**DELEGATED DECISION FOR APPLICATION FOR CERTIFICATE OF
LAWFUL DEVELOPMENT**

Reference no.: 2021/CL/91210/E

Site: Windmill Church Of England Primary School,
Upper Batley Lane, Batley, WF17 0NP

Description: Certificate of lawfulness for proposed car park
extension

TITLE
Car Park Parking Extension General Arrangement

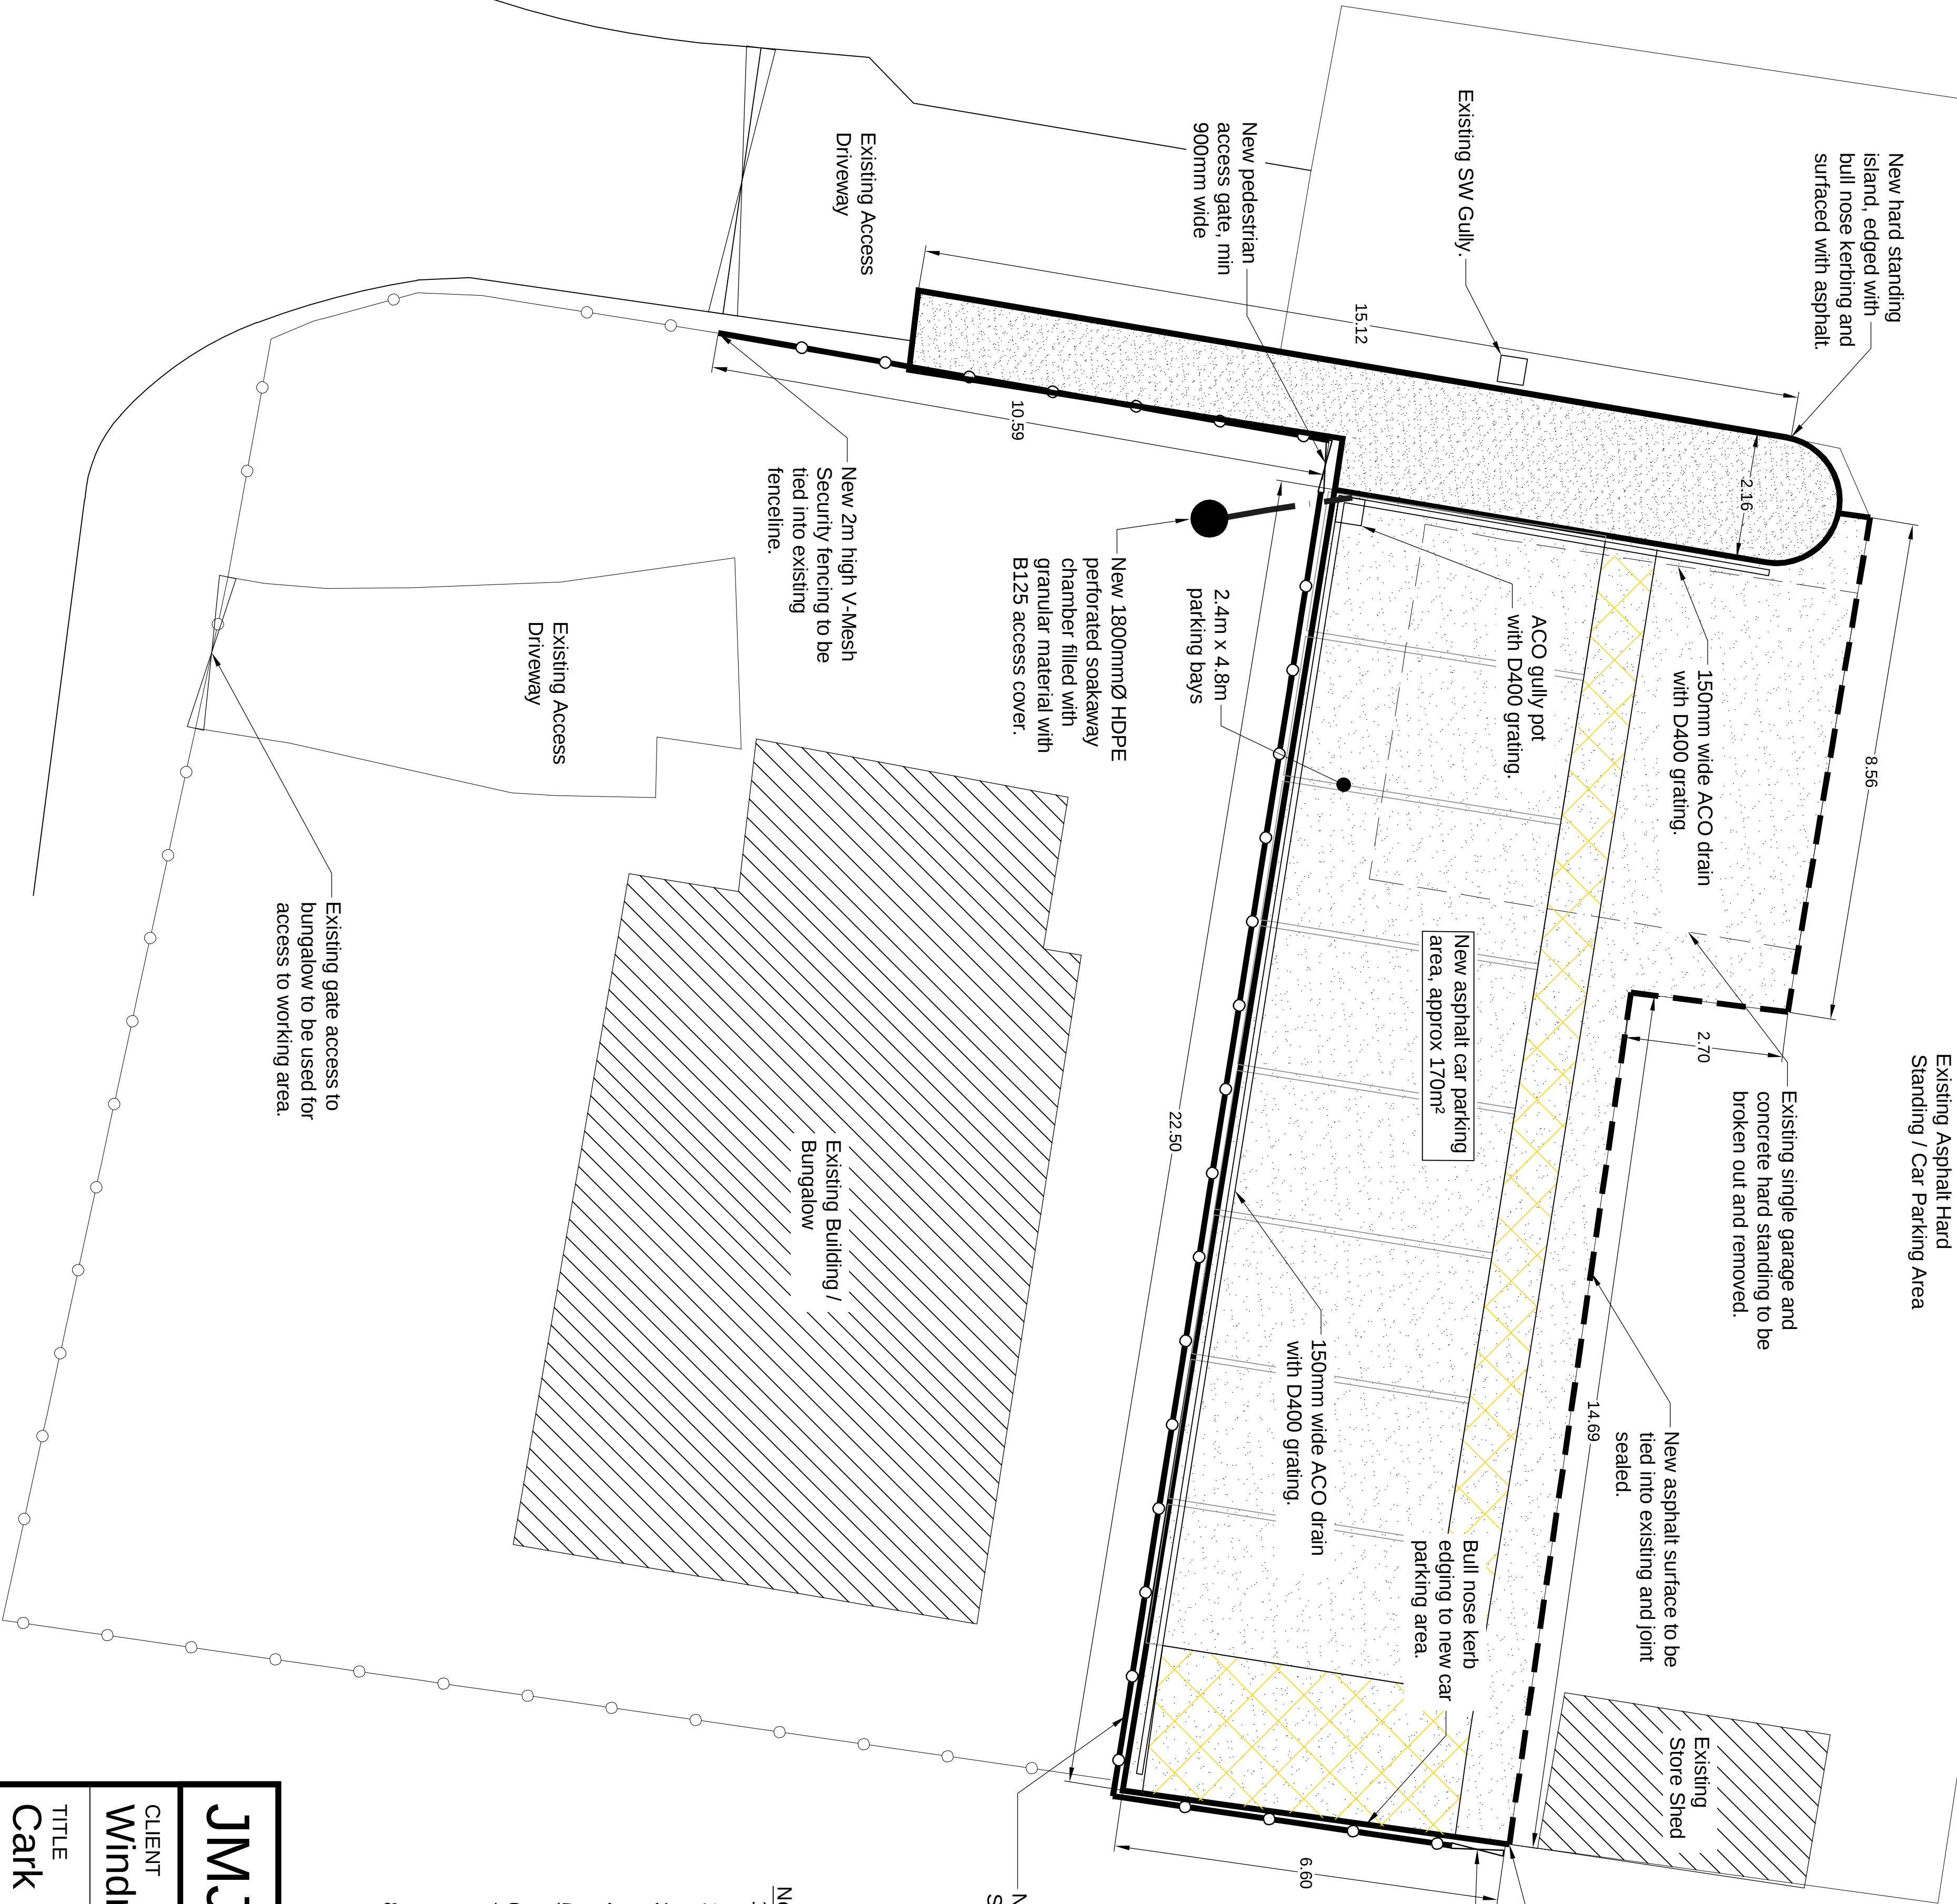
The plans indicated this area would be surfaced to provide parking for 8 vehicles within the grounds of the school. The caretaker's bungalow would have originally been an ancillary use to the school and the recent change of use application brought the site firmly into the school unit.

The area to be surfaced over the area currently surfaces would cover approx. 102sqm. This is in excess of the limitations set out and as such the proposal does not meet this criteria.

The proposed hardstanding within the grounds of Windmill Church of England Junior School would not meet the criteria for permitted development as set out in Schedule 2, Part 7, Class N of the Town and Country Planning (General Permitted Development) Order 2015 as the resultant hardstanding is more than 50sqm.

The proposed hardstanding within the grounds of Windmill Church of England Junior School would not meet the criteria for permitted development as set out in Schedule 2, Part 7, Class N of the Town and Country Planning (General Permitted Development)(England) Order 2015 (as amended) as the resultant hardstanding is more than 50sqm in area contrary to paragraph N.1(a) of Class N..
